Re: BusConnects Bray to City Centre Core Bus Corridor Scheme
Bray to Dublin City Centre.

BRAY TO CITY CENTRE CORE BUS CORRIDOR SCHEME

Strategic Infrastructure Development Application

Bord Pleanála Case reference: [KA27.317780](#)

Image 3.13: Section 3 Route Options Remaining After Stage 1 Sifting (Bray to UCD CBC Feasibility and Options Report (NTA 2017))

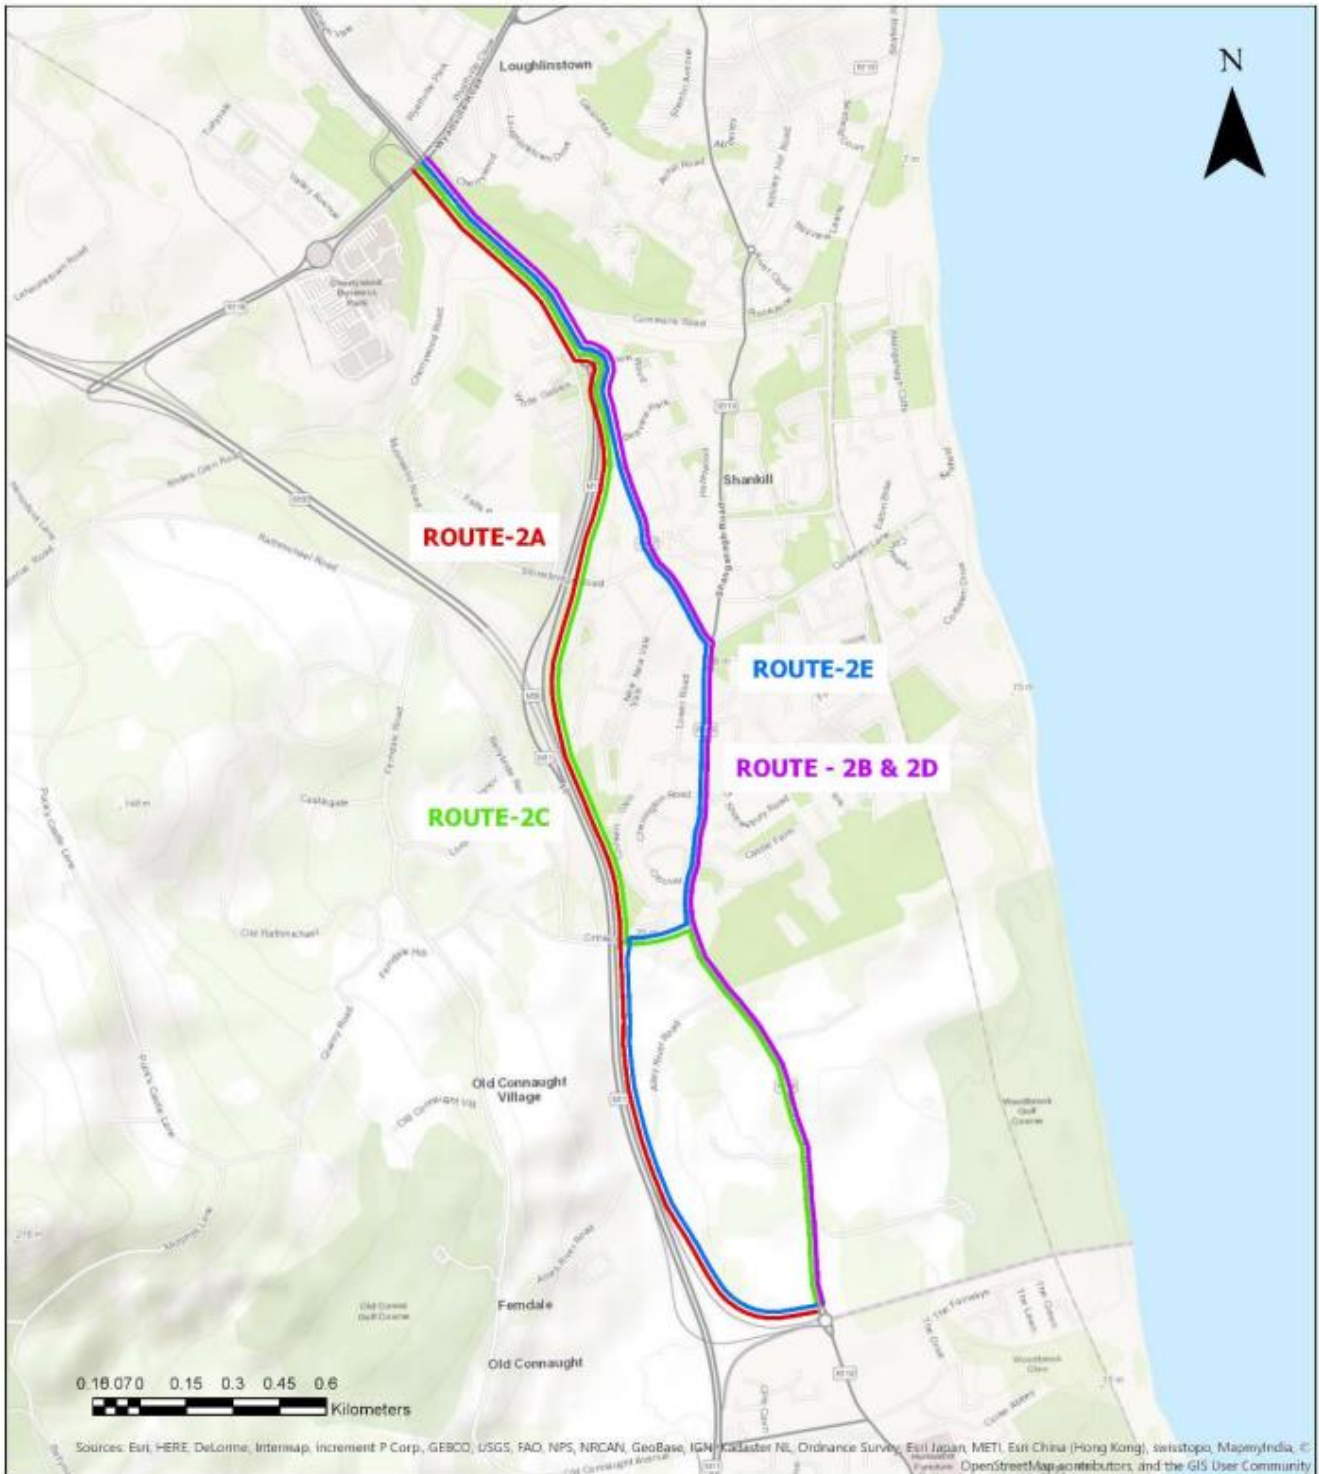
I wish to focus on Route Option 2A. I contend that Route 2A was never a viable option. The proposed alignment on the eastern side of the M11 coincides with the proposed alignment for the future extension of the Luas Green Line from Brides Glen to Bray, as set out in the Bray and Environs Transport Study 2019, see Fig 1. This alignment is confirmed in the Dun Laoghaire-Rathdown County Development Plan, see Fig 2.

South of Crinken Lane bridge, there is generally adequate space to accommodate the future Luas Line and a dedicated two way bus lane with cycle track provision. However, north of the Lordello Road footbridge this is not the case. There are pinch points at Newvale and at Stonebridge Close between Lordello Road footbridge and Stonebridge Road. There are further pinch points north of Stonebridge Road at Stonebridge Wood and Newbank.

Allowing a bare minimum of 3m for each bus lane and Luas track, consistent with the cross section for the dedicated busway presented in the Feasibility document and allowing 1.5m edge distance gives an absolute minimum reservation width of 15m. Whatever about being able to avail of lands within the current motorway reservation adjacent to Stonebridge Close, it would not be possible to accommodate this width of reservation for both Luas and Busconnects at the corner of Newvale, at Stonebridge Wood and at Newbank. In the case of the latter two locations, a number of recently constructed houses would have to be demolished. Of course, this could be done – but none of this was referenced in either the Feasibility and Options Report or in Chapter 03 of the EIAR –

Consideration of Reasonable Alternatives. Although the EIA Directive does not require a mini-EIA for each of the alternatives presented, it surely does require that the options tabled are at least viable and that all principal relevant constraints have been identified. This has not been done in the case of Options 2A, 2C and 2D and none of these Options is therefore viable or valid.
